Arborist Report

Site: Matthew Wiley Property
6838 96th Ave SE, Mercer Island

Re: Tree Inventory

Date: September 15, 2021

SHEET
TREE RETENTION PLAN
C101

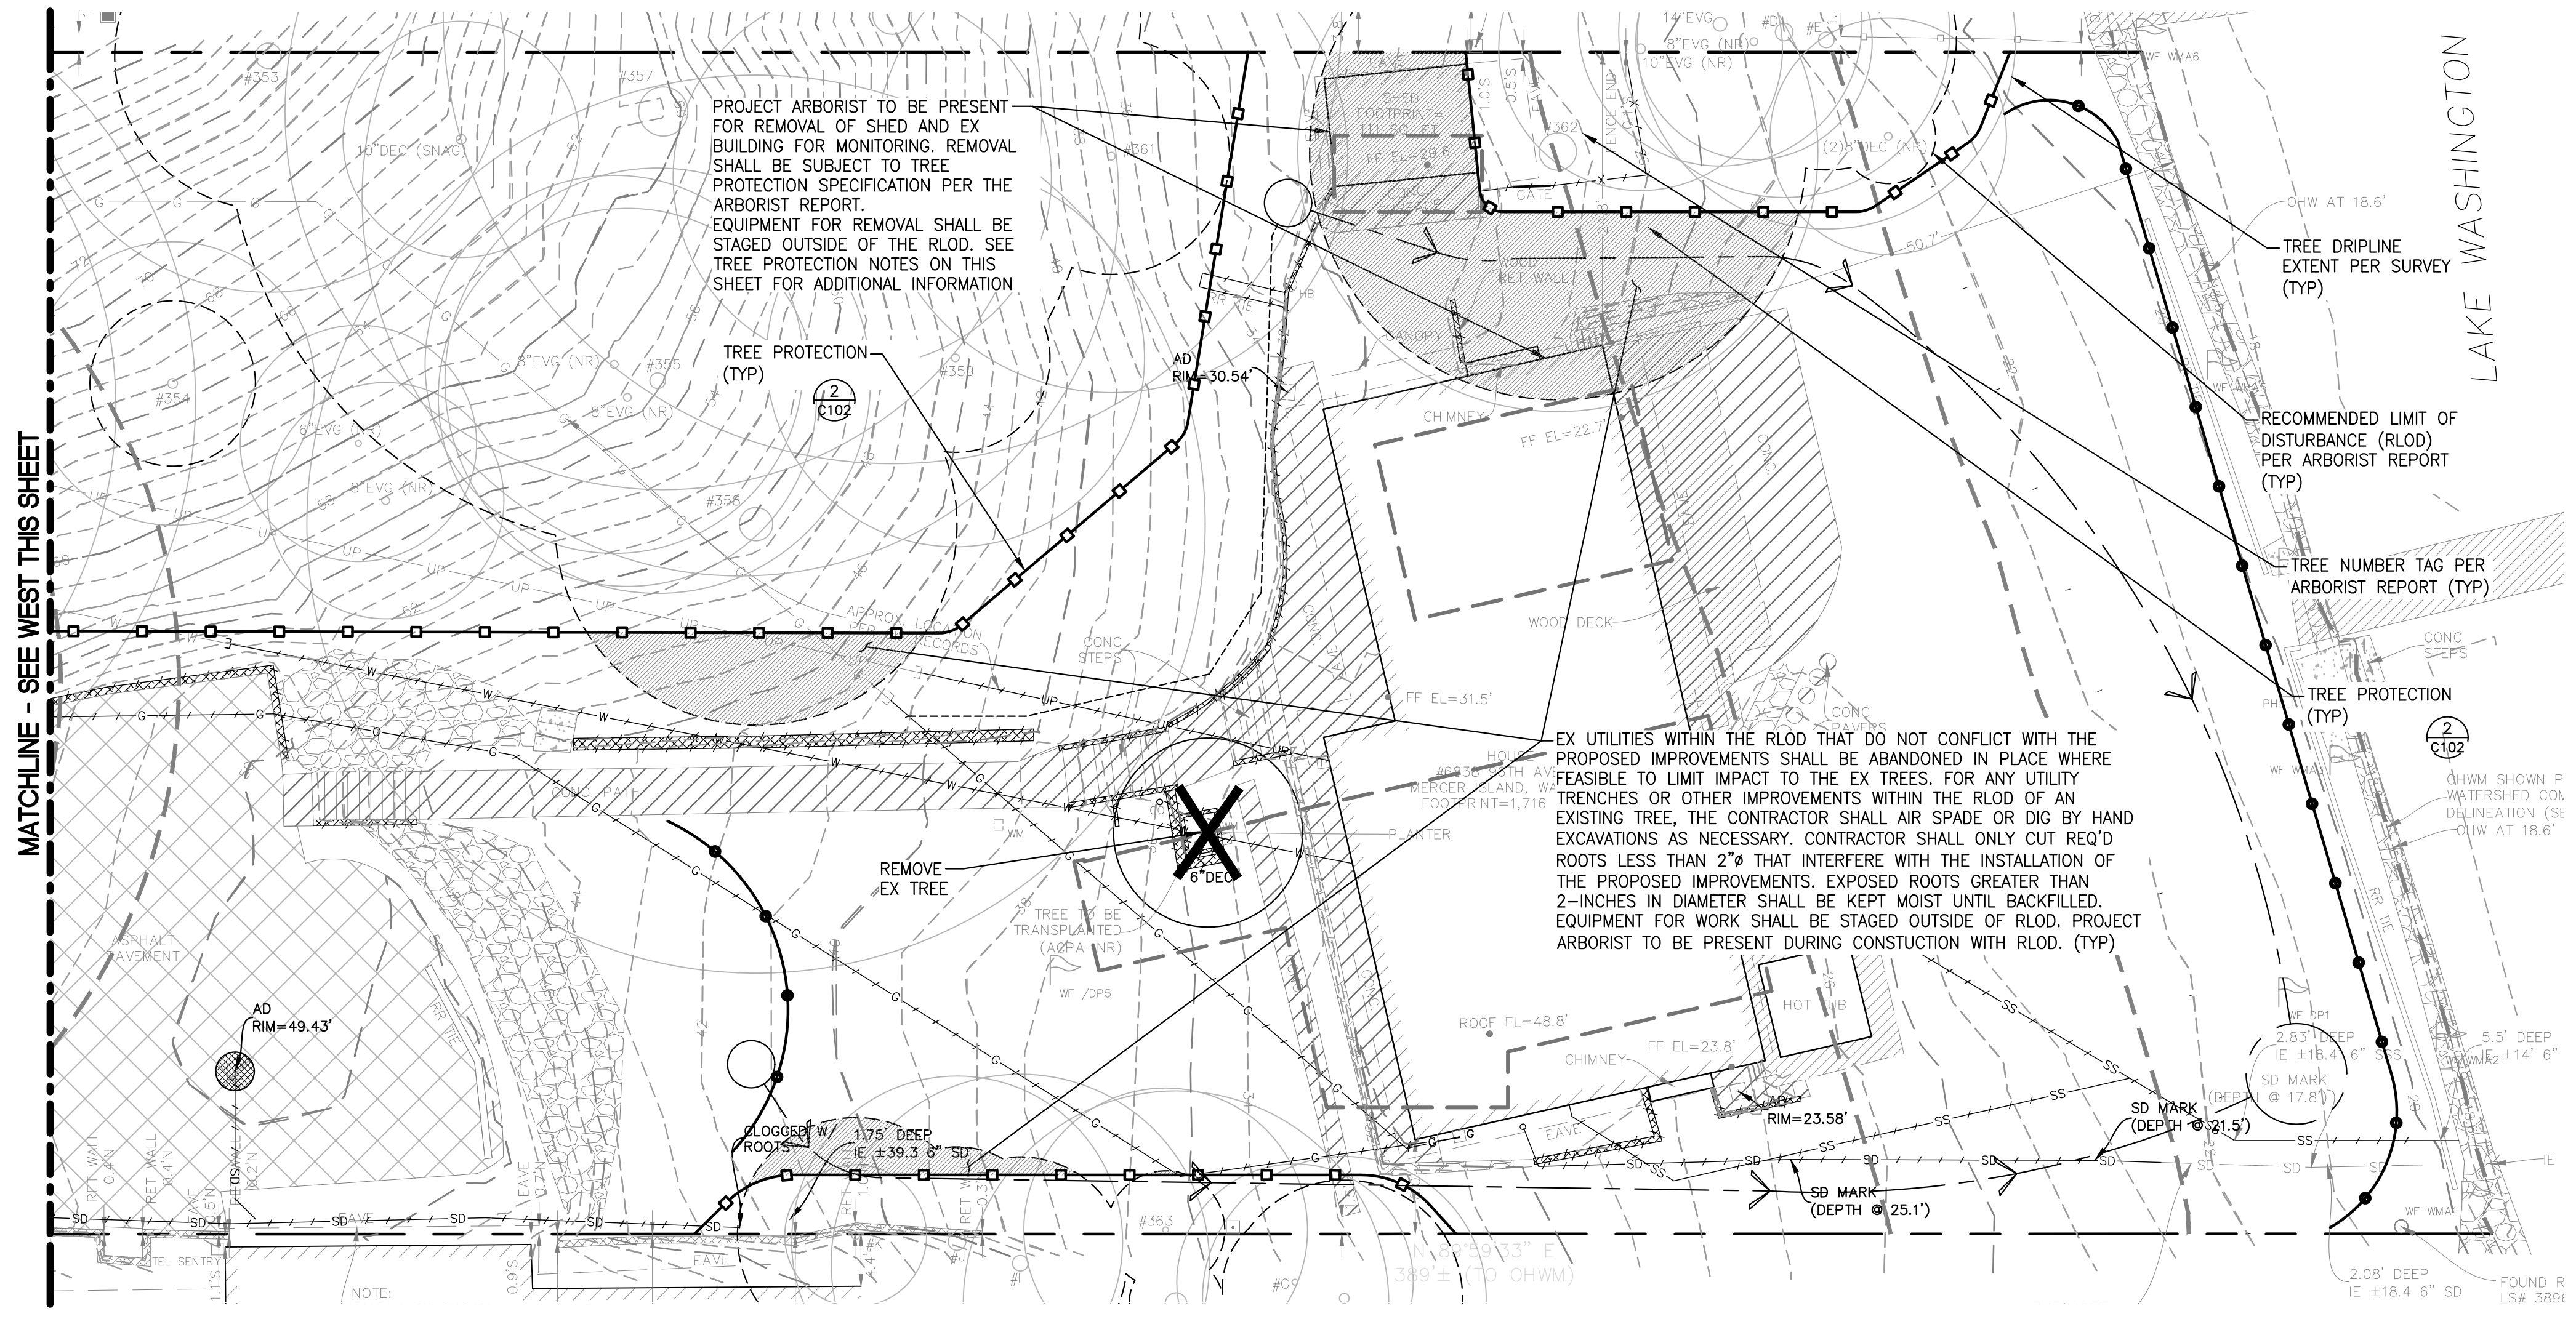
- Obtain all necessary permits and approval from the City prior to commencement of site work.
- Update plans to:
 - Show the limits of disturbance for all retained trees on and off site.

- Show the location of tree protection fencing.
 - Identify areas where required work falls within a tree protection area, particularly where fencing may not encompass the area due to existing infrastructure.

- Include notes to show that work within the tree protection area may require arborist monitoring and is subject to alternative methods and tree protection specifications as outlined in Appendix F.

- This is particularly important near trees 344, 362 and the row of off-site trees along the southern property line (trees F through K)
 - Type of erosion control used within tree protection areas.

GRADING AND DRAINAGE PLAN
C200

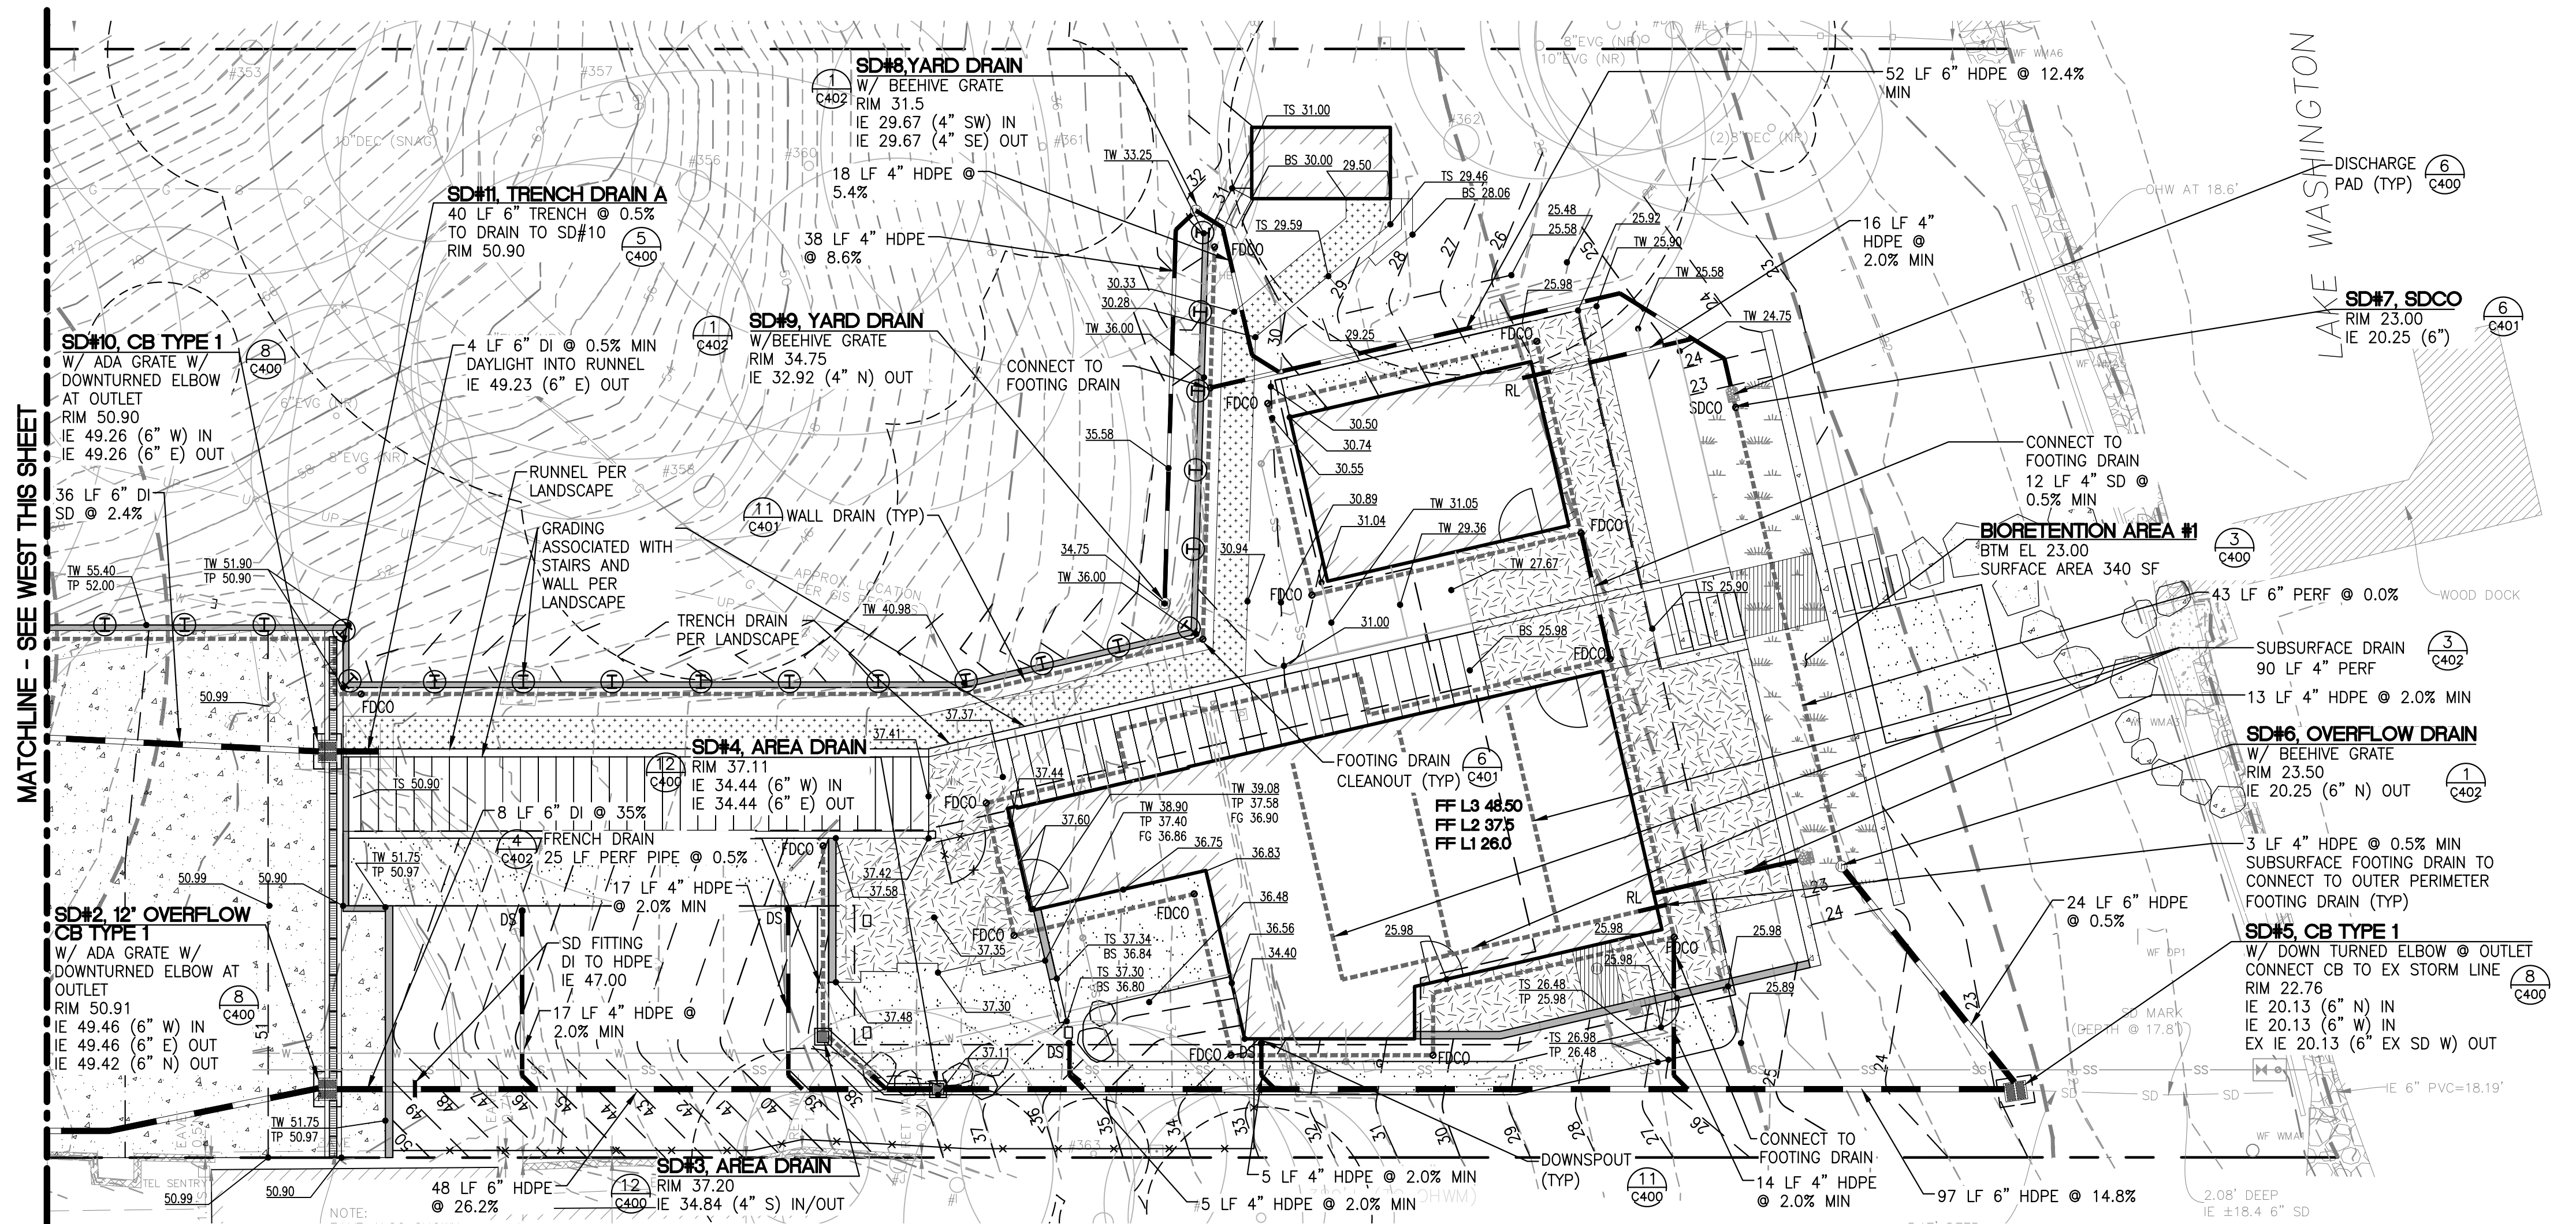
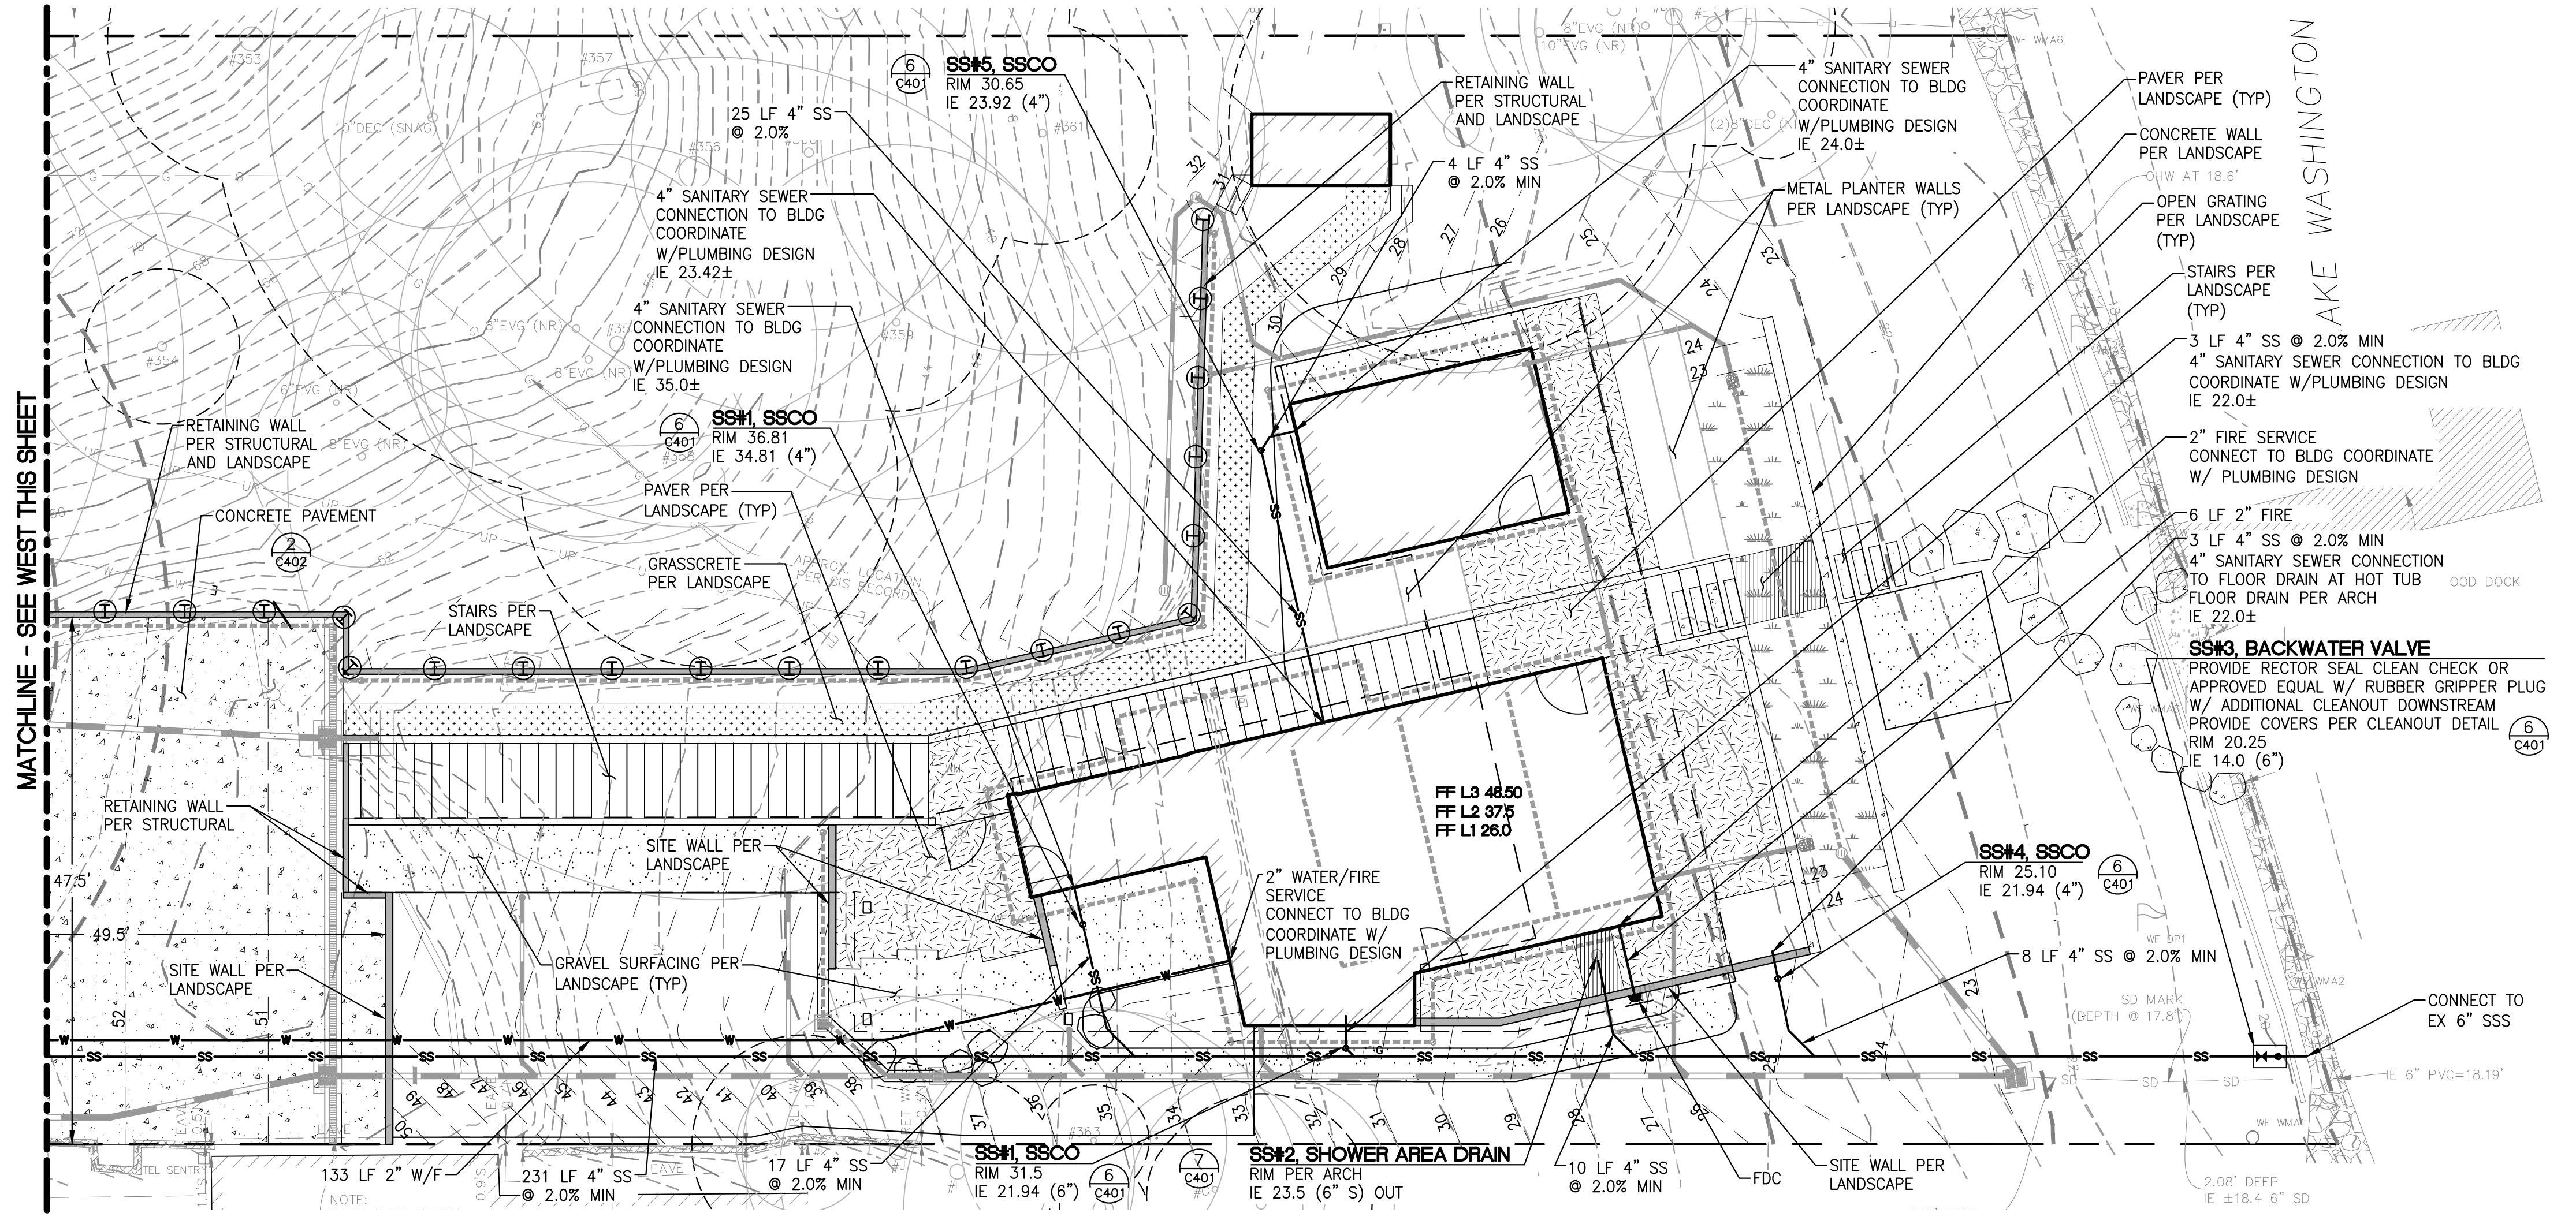
The Civil Progress Set dated 8/27/2021 shows storm drainage lines running through the tree protection areas of tree 362 and off-site trees F through K. Per a project meeting with Miller Hull and LPD Engineering, these lines will be relocated to outside the limits of disturbance for these trees; Tree Solutions has not verified that plans have been updated at this time.

The storm line near 362 should be adjusted to follow the footprint of the house as closely as possible. While this is still within the RLOD, because of existing site conditions it is our opinion the impacts to the tree will be minor if the line location is adjusted.

The storm line near F through K should be relocated north, outside the RLOD.

Excavation required for storm infrastructure near retained trees should be monitored by the project arborist. Any roots larger than 2-inches diameter should be retained and worked around or cut cleanly. The arborist monitoring site work can guide root management during work and assess potential root impacts.
